31 Sea Way Ref. No.M/56/15/HH

I am writing to urge you to reject this amended application on similar grounds to those raised in my letter of objection to the original proposals. These were the gross over development of this small site, the over bearing nature of the extensive buildings so close to the boundary with no. 29 and the garage structure at the front of the site.

Proposed Floor Plans
- Ground Floor
- First Floor
- Roof Plan

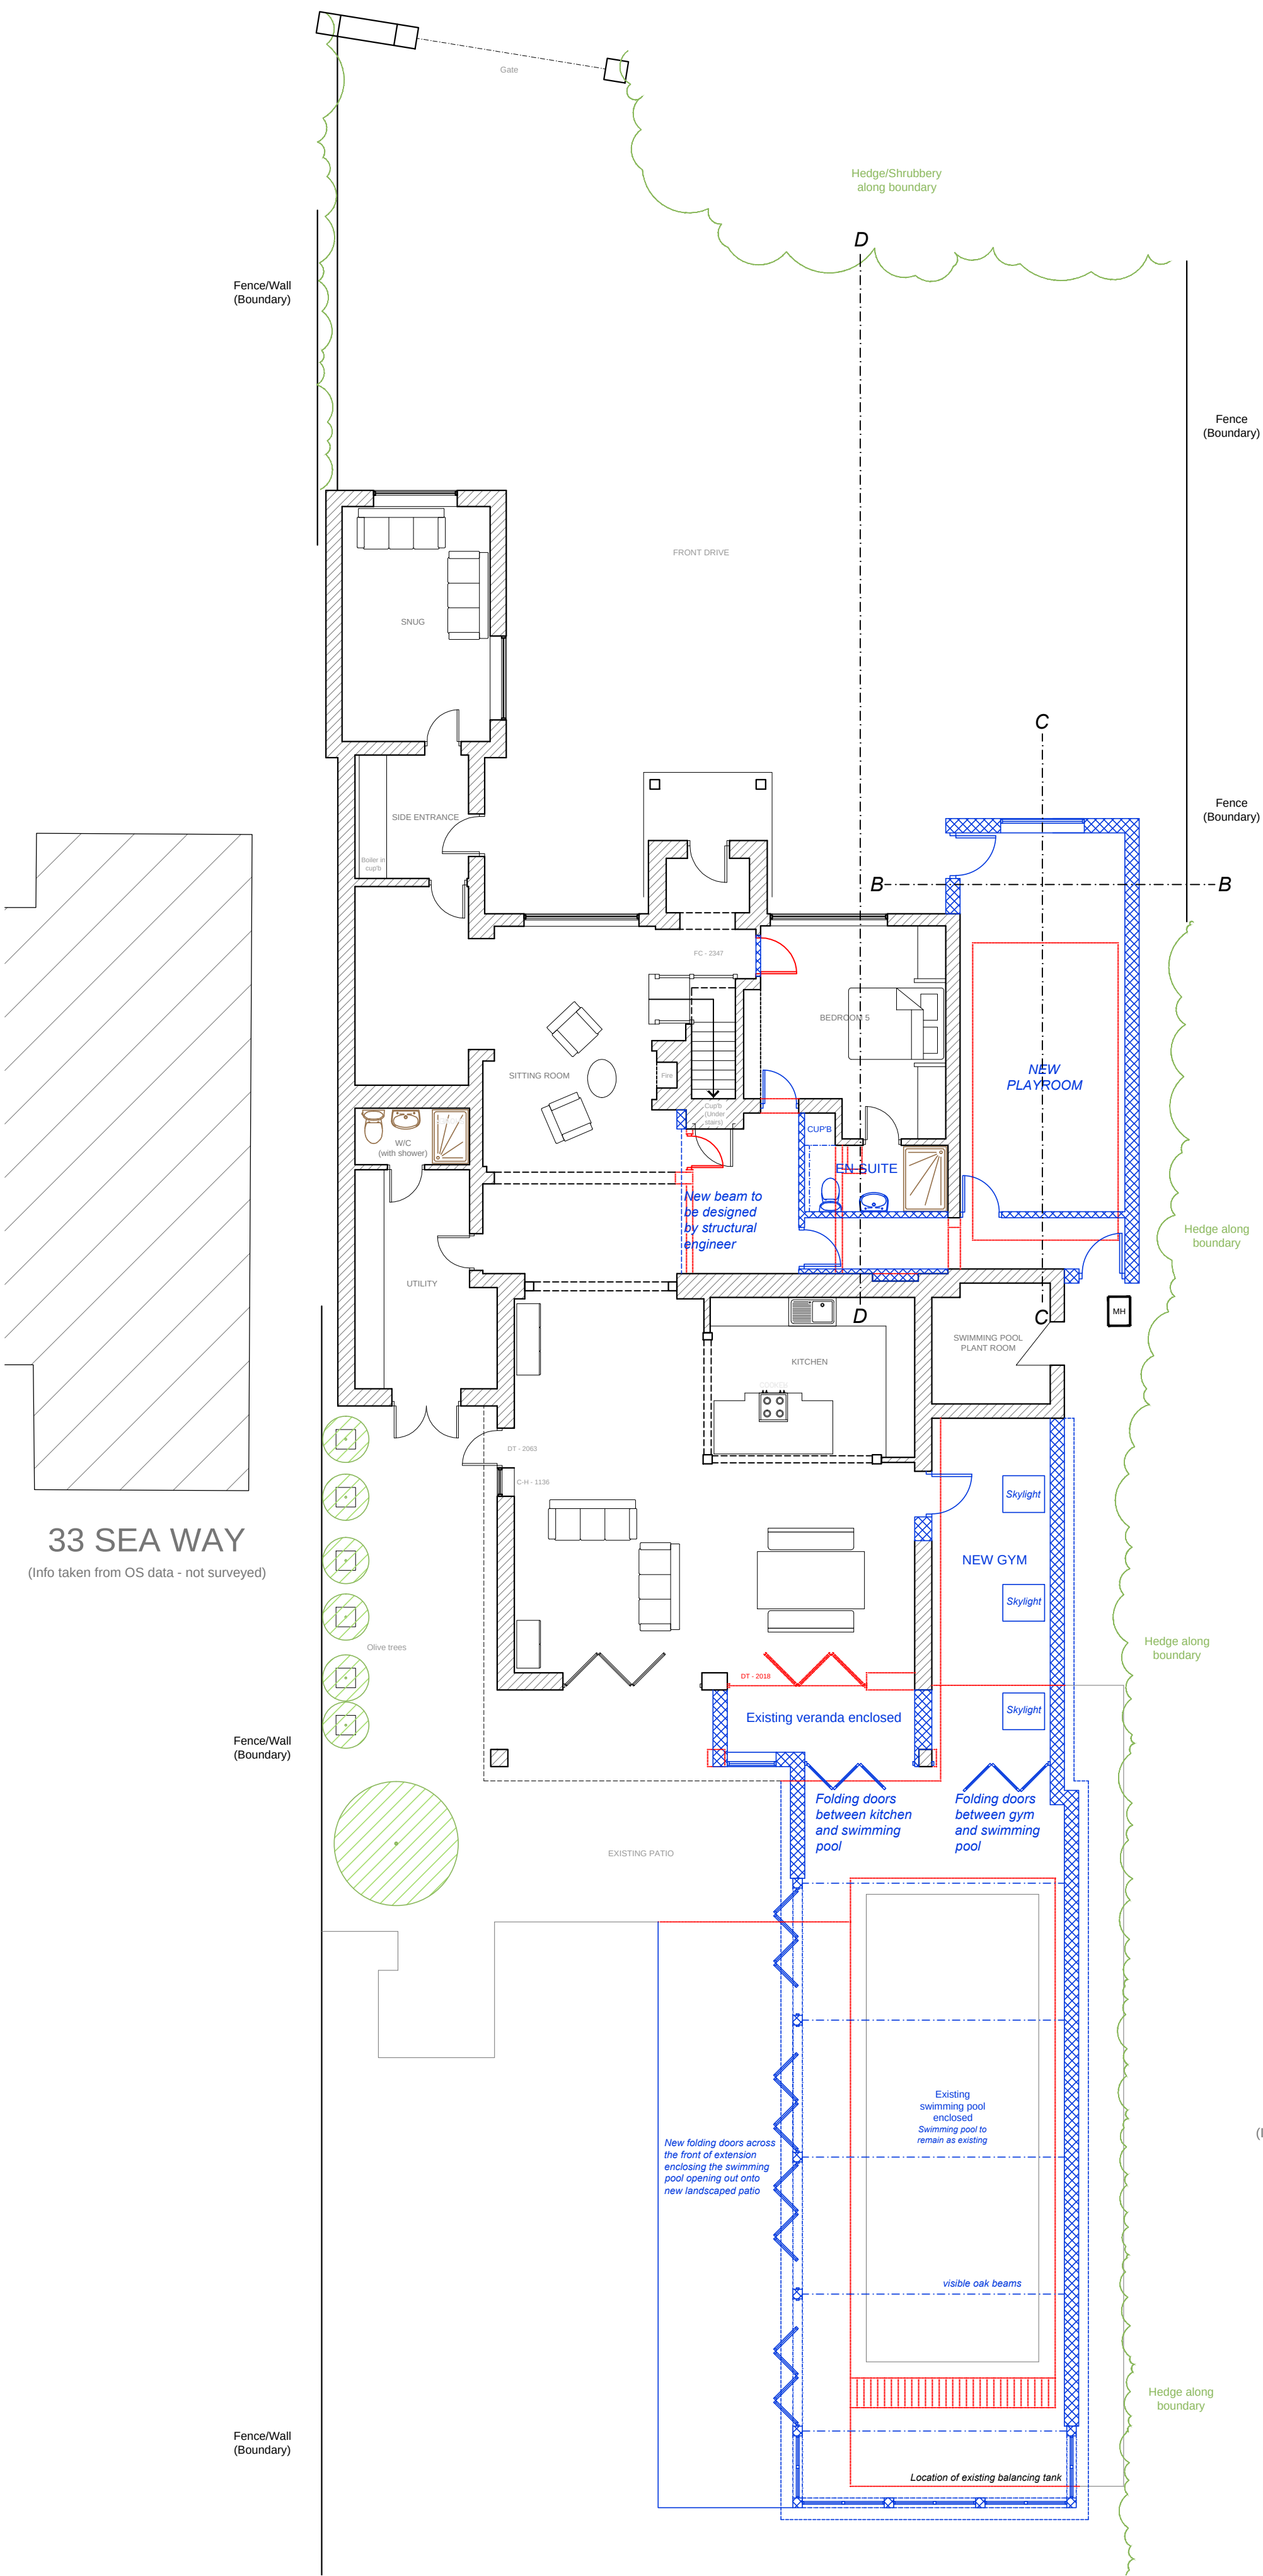
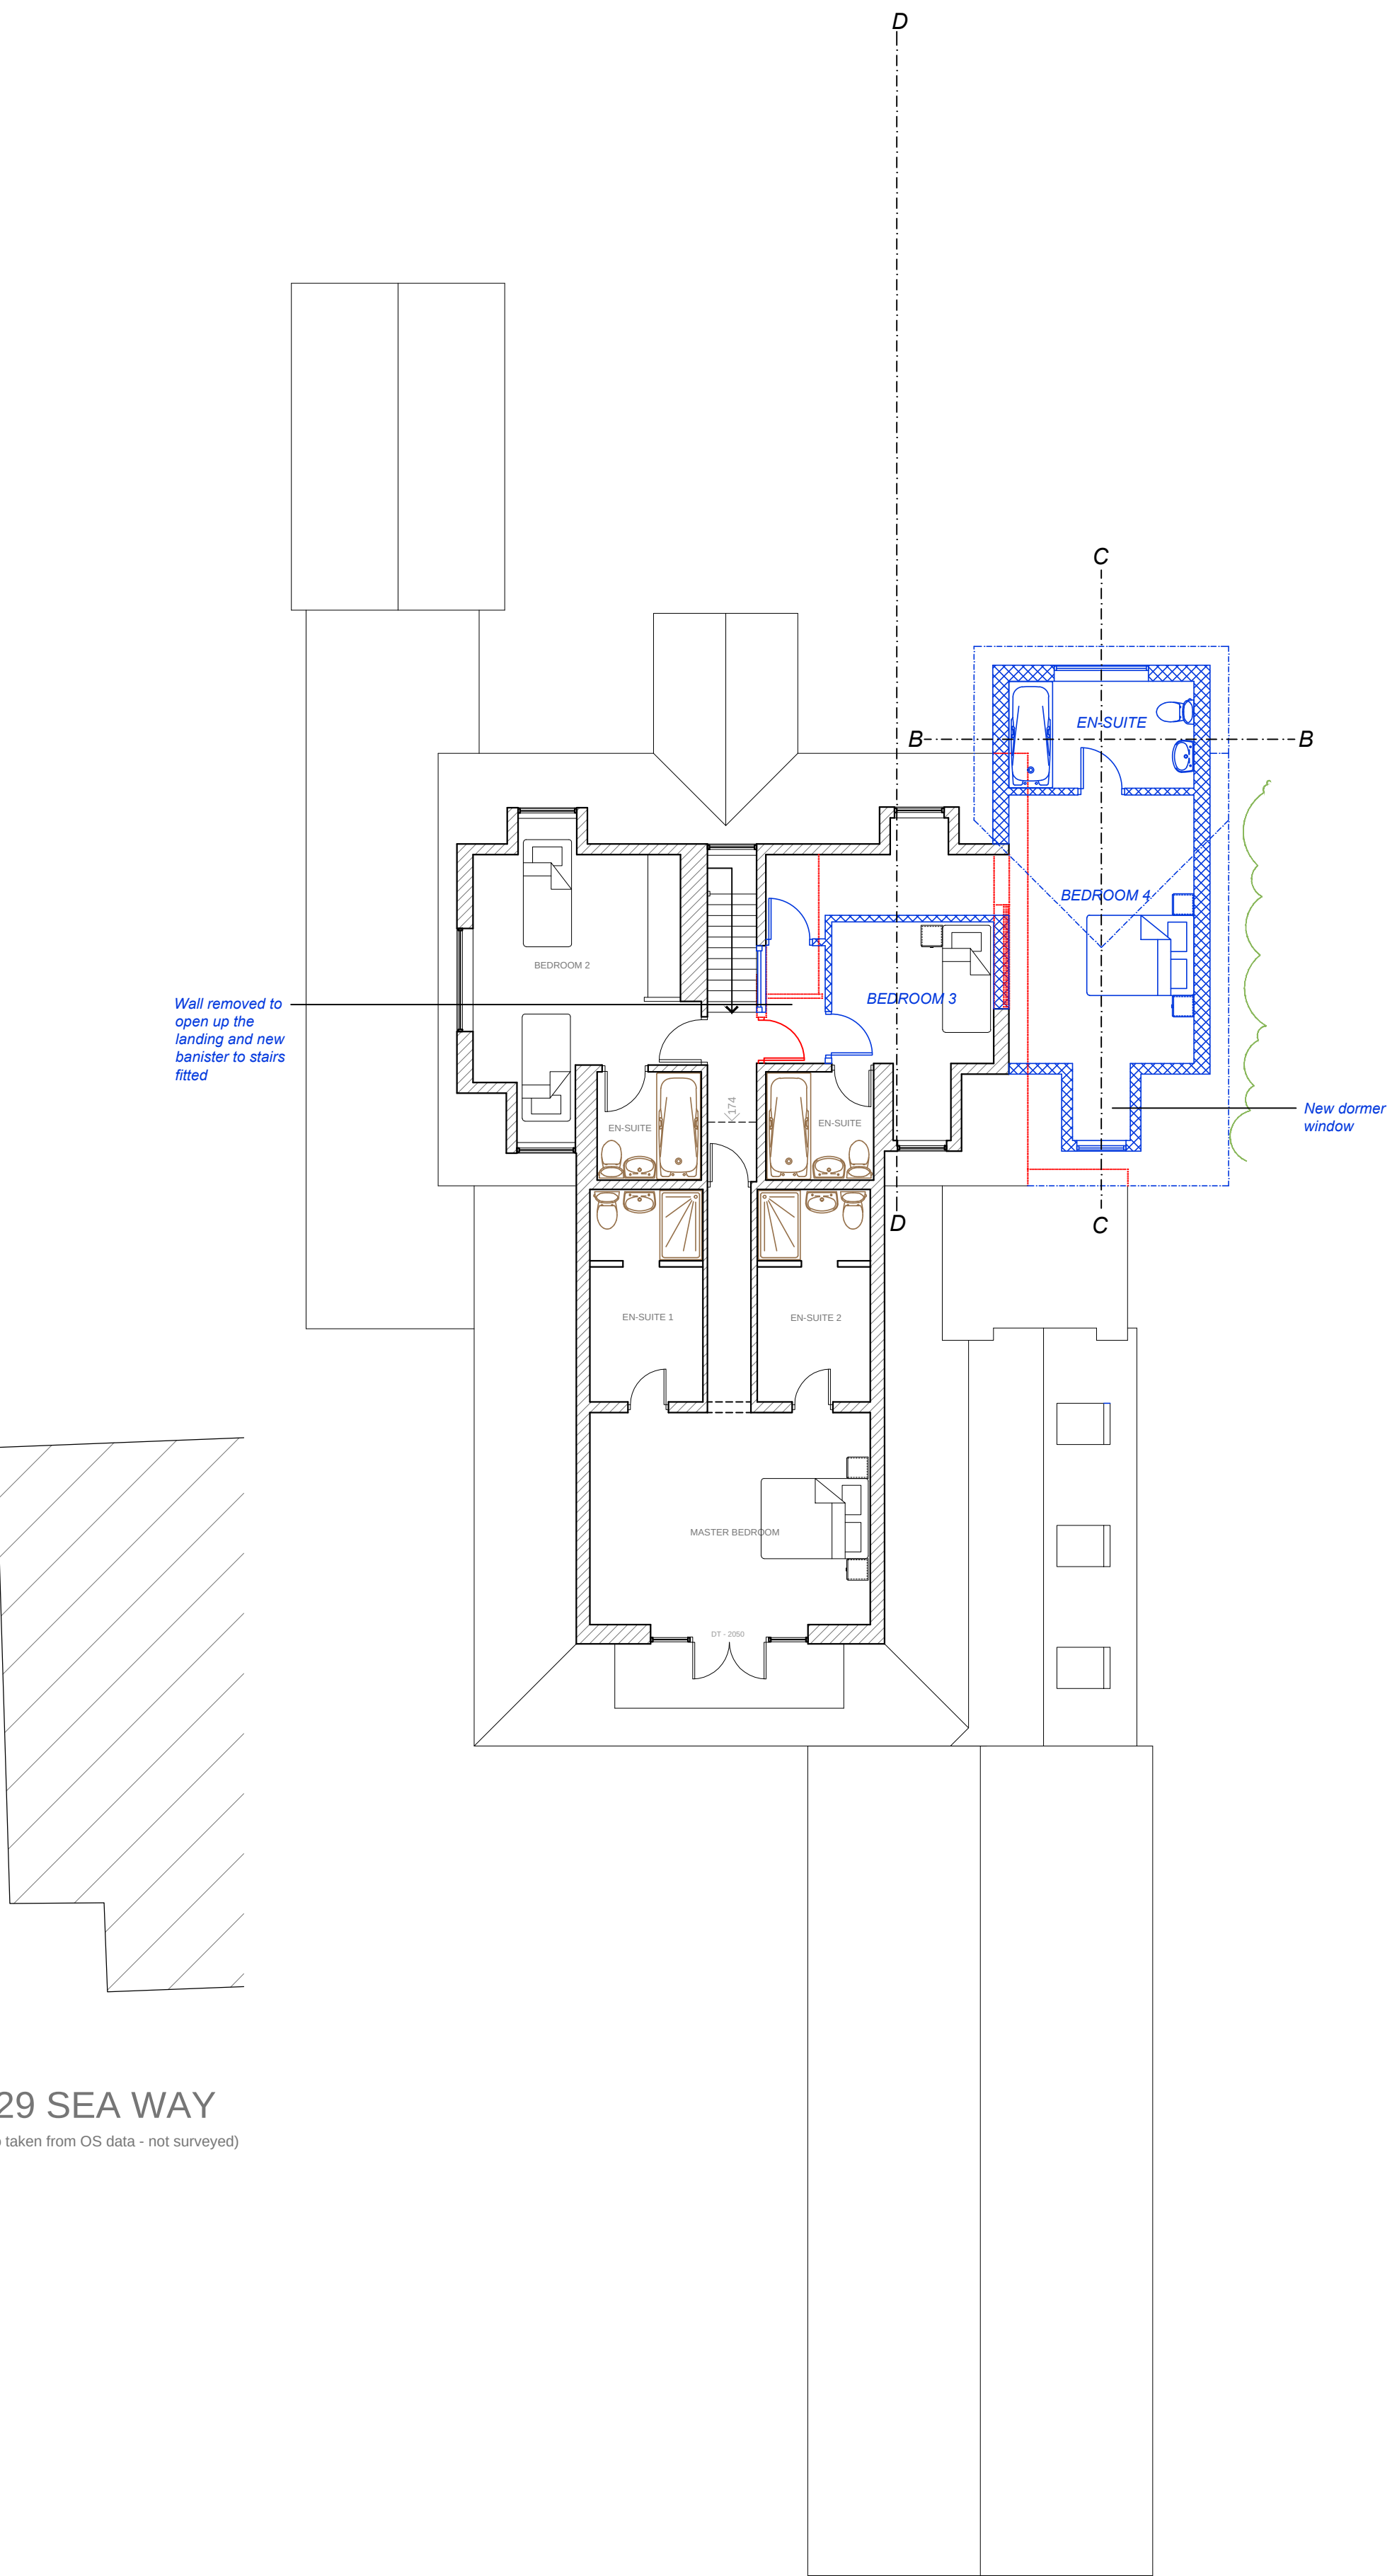
I appreciate that there was a previous consent for the two storey extension but I would ask that this be reconsidered in regard to the close proximity with the boundary and building No.29. A distance of less than one meter from the boundary close by the adjoining house is, surely, not in accordance with the space around buildings described in the VDS.

Surface Water Drain
Sea Way
Middleton-on-Sea

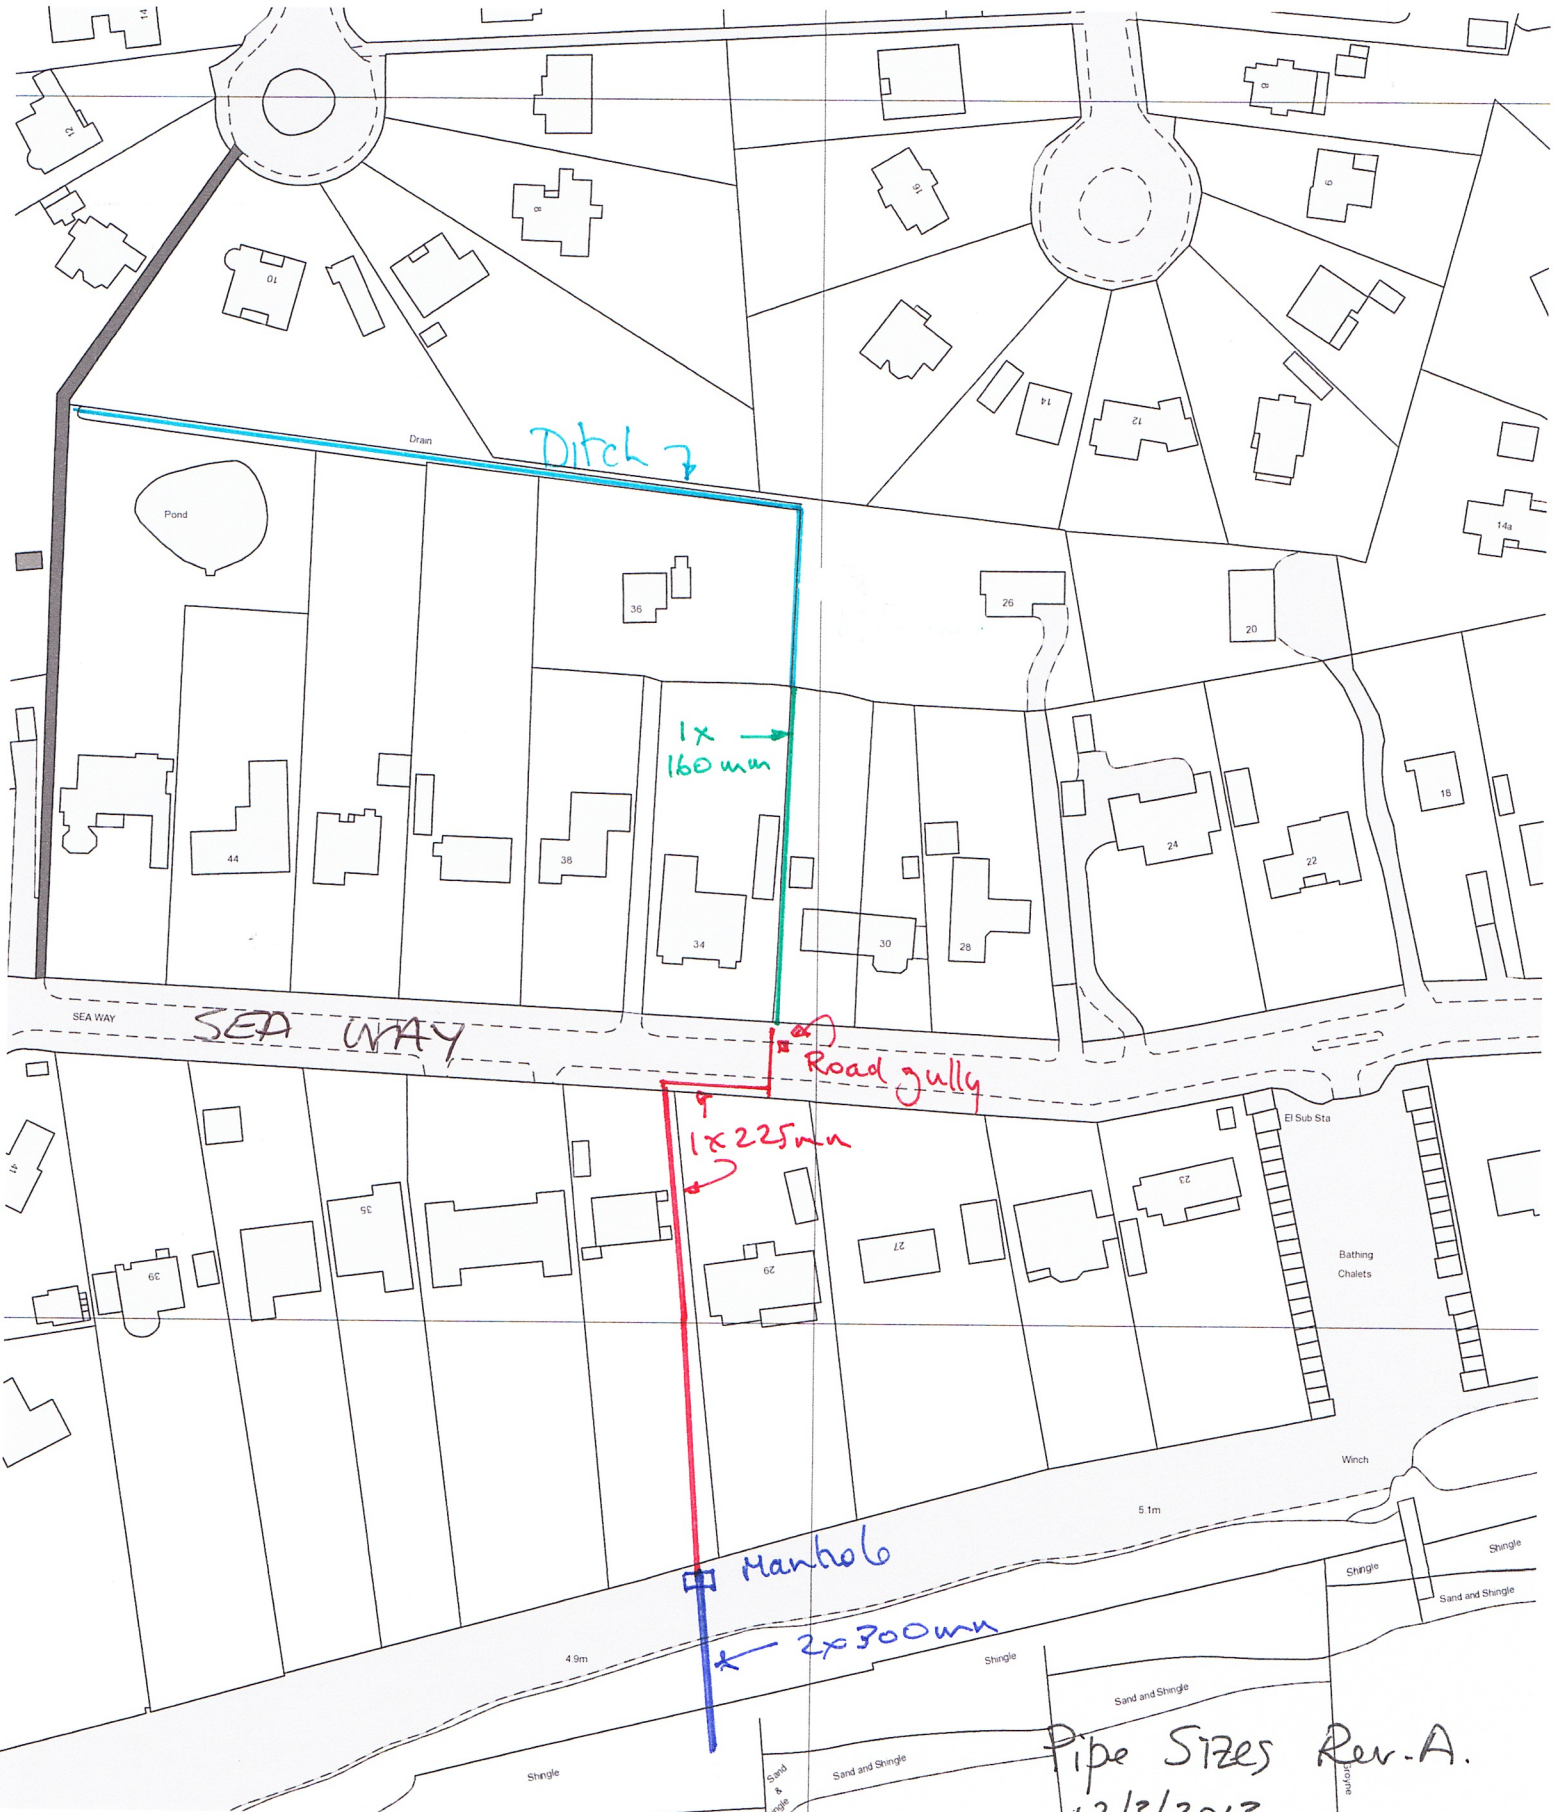
I am very concerned about the impact these buildings could have on a recently renewed private land drain running through this site discharging out to sea and serving this and several other houses and the road itself. This should be shown on the drawings to enable the effect of the proposed buildings on the drain to be judged. This drain was provided at considerable cost to the residents of Sea Way and must be safeguarded and kept clear and available for easy access and repair when necessary.
